**RE: The Wymont**  
**4315 Wyoming Blvd NE**  
**Engineer's Certification Date: 09/21/23**  
**Engineer's Stamp Date: 01/27/22**  
**Hydrology File: G19D004**  
**CPN: 568482**

Based on the Certification received 11/06/23 and site visit on 11/07/23, this certification is **not** approved in support of ROFG/SIA by Hydrology. The following comments need to be addressed for approval of the above referenced project:

<b>THE WYMONT ALBUQUERQUE, NM</b>	DRAWN BY pm
	<b>STORM SEWER PLAN</b>	DATE 1-27-2022
	<b>TIERRA WEST, LLC</b> 5571 MIDWAY PARK BL NE ALBUQUERQUE, NEW MEXICO 87109 (505) 858-3100 www.tierrawestllc.com	DRAWING 2021008-GR
		SHEET # <b>GR-4</b>
		JOB # 2021008

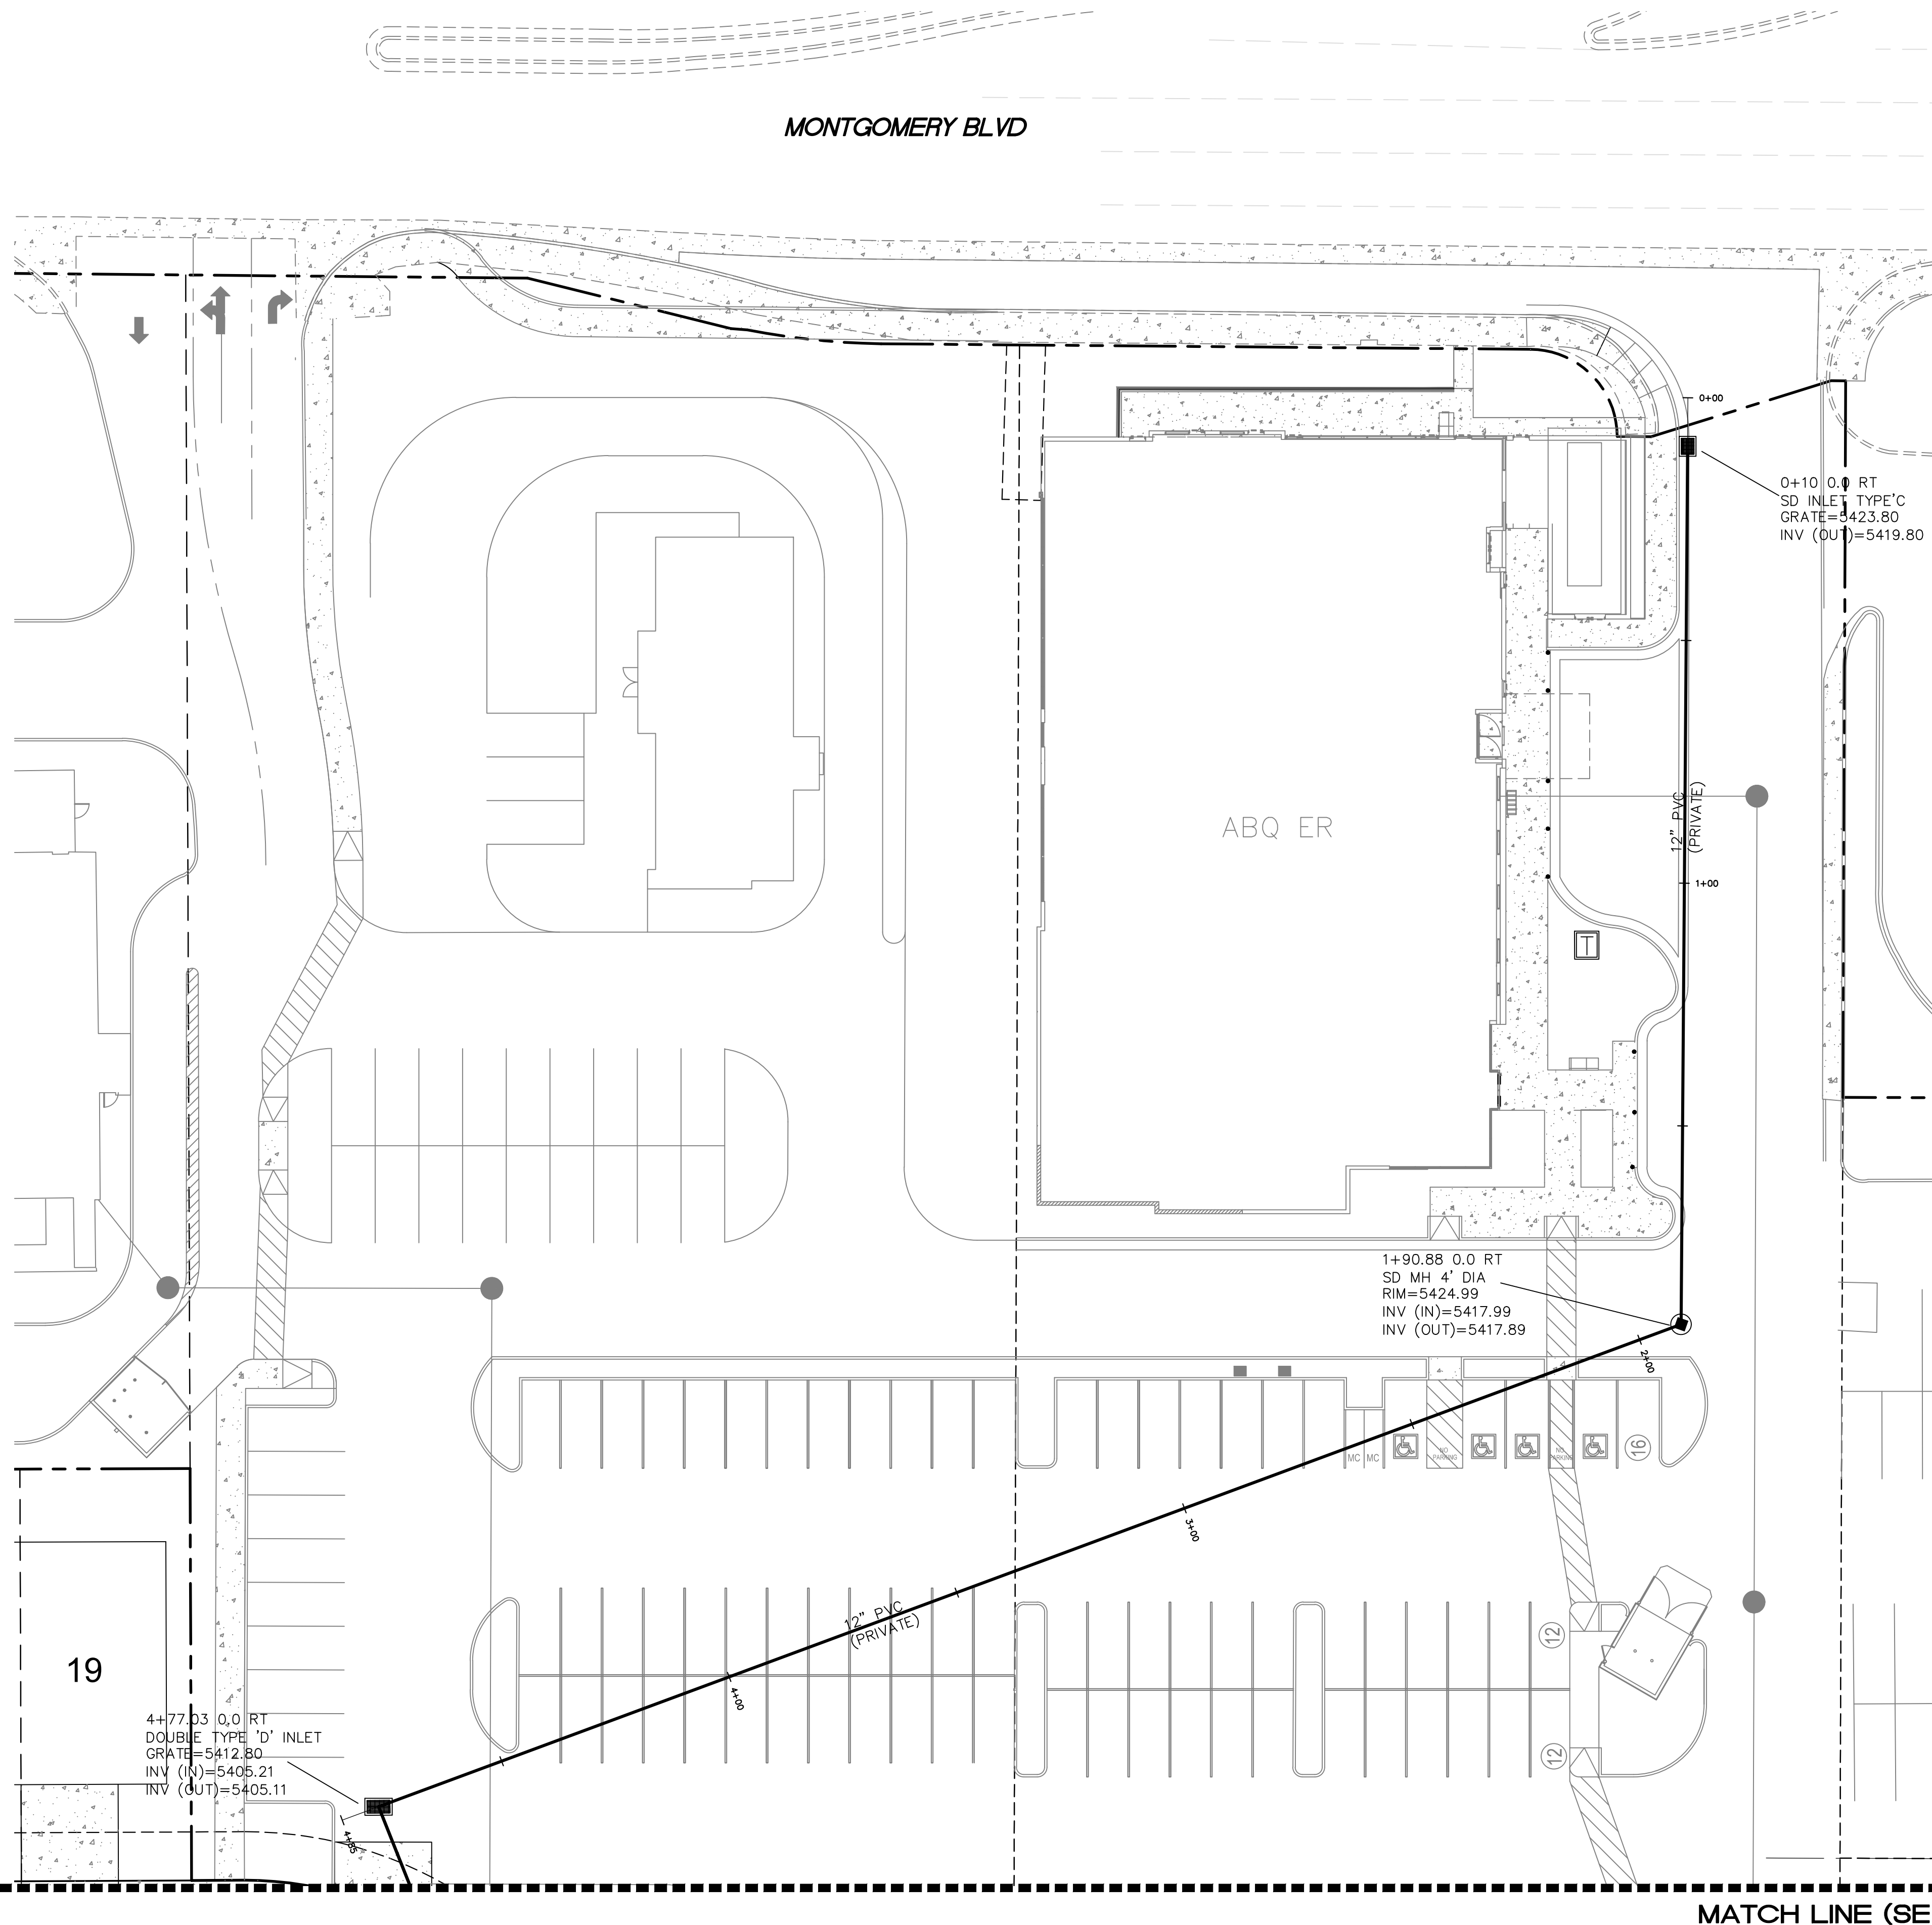
1. The following are deficiencies that I noted in my site visit which are in the Work Order Plans. These items need to be installed.
  - a. Sidewalk culvert
  - b. Concrete rundown
  - c. Maintenance ramp needs to fix it does not look as if they knew what they were installing.
  - d. The gate does not align so that a Bobcat can get in, go down the ramp and do proper maintenance.
